# Norwich to Tilbury

**Document: 8.5.5 Applicant's Response to the Oral Submissions Made  
at the Open Floor Hearings**

**Planning Inspectorate Reference: EN020027**

1) Figure A13.5.3 with Overlays to compare discrepancy in Noth vs south impact on the ZTV

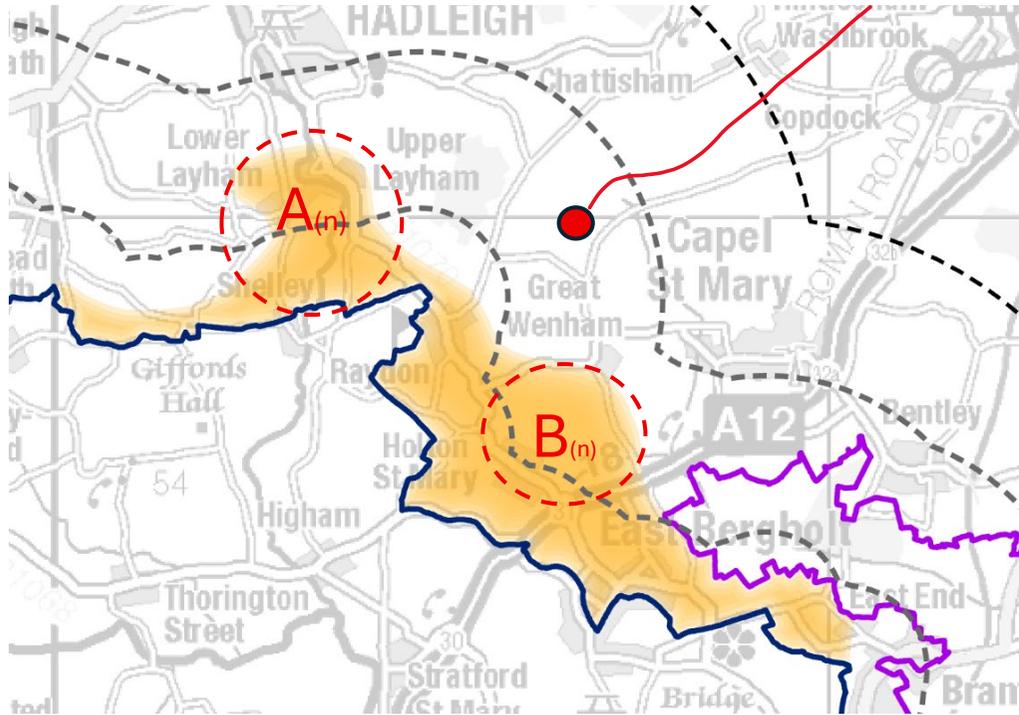
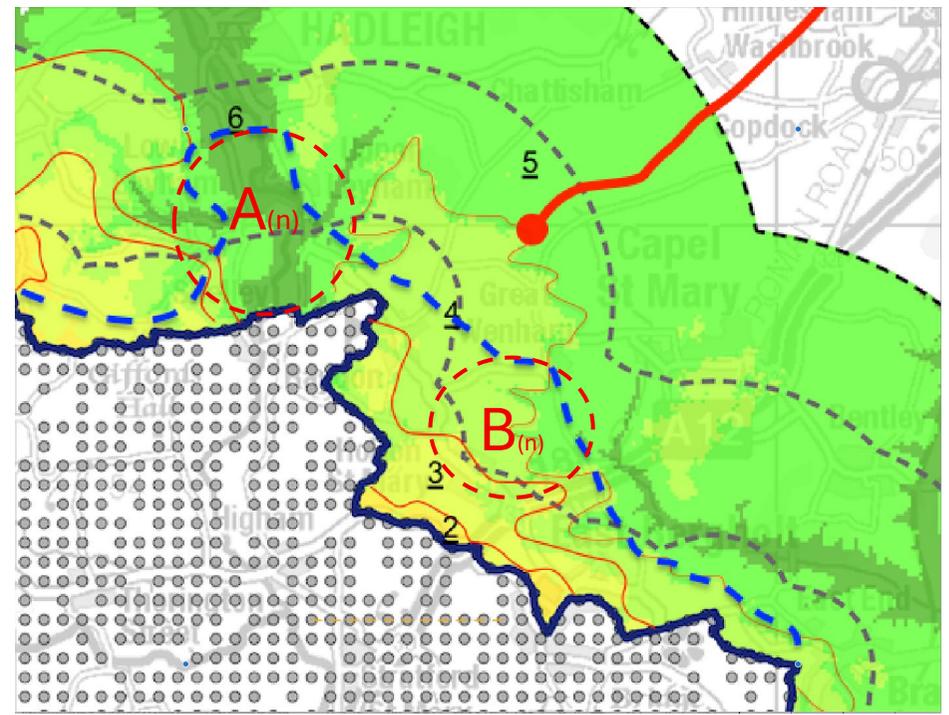
<p>The IPs' document refers to the reverse ZTV in Figure A13.5.3 in <b>6.13.A5 Environmental Statement Appendix 13.5 - National Landscape Assessment Study [APP-235]</b>. The reverse ZTV illustrates the areas outside the National Landscape where the top half of 50 m high structures would potentially be visible from within the National Landscape; it does not represent theoretical visibility of the Project and associated infrastructure as stated in the comments. Further detail about the reverse ZTV is provided in paragraphs A.5.42 to A.5.49 of <b>6.13.A5 Environmental Statement Appendix 13.5 - National Landscape Assessment Study [APP-235]</b>.</p> <p>The setting study for the National Landscape is set out in Annex A of <b>6.13.A5 Environmental Statement Appendix 13.5 - National Landscape Assessment Study [APP-235]</b>. The study considered areas where vertical infrastructure would be visible in views to and from the National Landscape and also areas with similar landscape characteristics which contribute to the character, qualities and sense of place of the National Landscape. The setting was not defined by the reverse ZTV alone. Site visits were undertaken to inform the study.</p>

Organisation	PINS ref	Third party comment	Applicant's Response
		<p>from the National Landscape boundary compared to their derived visual setting at 2km on the zone 4 and 5 boundary. Their documentation states one of the reasons it was moved further away after previous consultation was to reduce the visual impact on the National Landscape. You can also see that there are relatively low ZTV from the CSE and pylons from within the National Landscape.</p> <p>Page 3 shows the diagrams for the south. However, here there is a complete contrast. Their defined visual setting doesn't even cover the whole of visual zone 3 or any of zone 4. It doesn't include the similar area to Brett Vale, i.e. Fordham Valley. It's not only excluded from the visual setting, but has the pylons sited directly along it. Colne Valley, just to the west, is also excluded from the visual setting and is impacted also. One CSE and approximately four kilometres of pylons reside in zone 3, as close as 1.2 kilometres. [Inaudible] CSE and another four kilometres of pylons reside in zone 4, as close as 1.2 kilometres.</p> <p>Two of the CSEs have actually been located in the Applicant's own derived visual setting, almost 1km closer to</p>	<p>The Applicant agrees that the above ground elements of the Project are closer to the south than to the north (1.3 km and 2 km, respectively). The siting of CSE compounds was informed by a number of environmental and technical factors and not just landscape and visual considerations.</p> <p>The Applicant acknowledges the concerns raised regarding the potential effects of the Project around Ardleigh. There would be visibility of pylons around Ardleigh from the National Landscape as shown in Figures A13.5.8 and A13.5.9 in <b>6.13.A5 Environmental Statement Appendix 13.5 - National Landscape Assessment Study [APP-235]</b>. Project ZTVs were based on the individual pylon heights as set out in the Table of Parameters in <b>2.3 Works Plans - Sections A to H [APP-017 to APP-024]</b>. Further detail about the Project ZTVs is provided in paragraphs 13.6.3 to 13.6.7 of <b>6.13.A1 Environmental Statement Appendix 13.1 - Landscape and Visual Methodology</b>.</p> <p>The generation of a ZTV is a starting point for understanding the theoretical extents of visibility of the Project. In practice views will diminish with distance, as they become a smaller part of the view, as a result of perspective. While the Digital Terrain Model has been amended to include some buildings and woodland blocks, their maximum heights have been estimated. Other intervening screening vegetation, for example hedgerows and hedgerow trees, are not included and these may substantially filter views experienced by people walking along a PRoW or local lanes, even if it is near to the Project. It is therefore necessary to treat ZTVs as a tool, and to use them with caution. The ZTV is used as one of the tools available to a landscape practitioner, and tested through field work and modelling of photomontages, so that true visibility, in practice, can be better understood.</p>
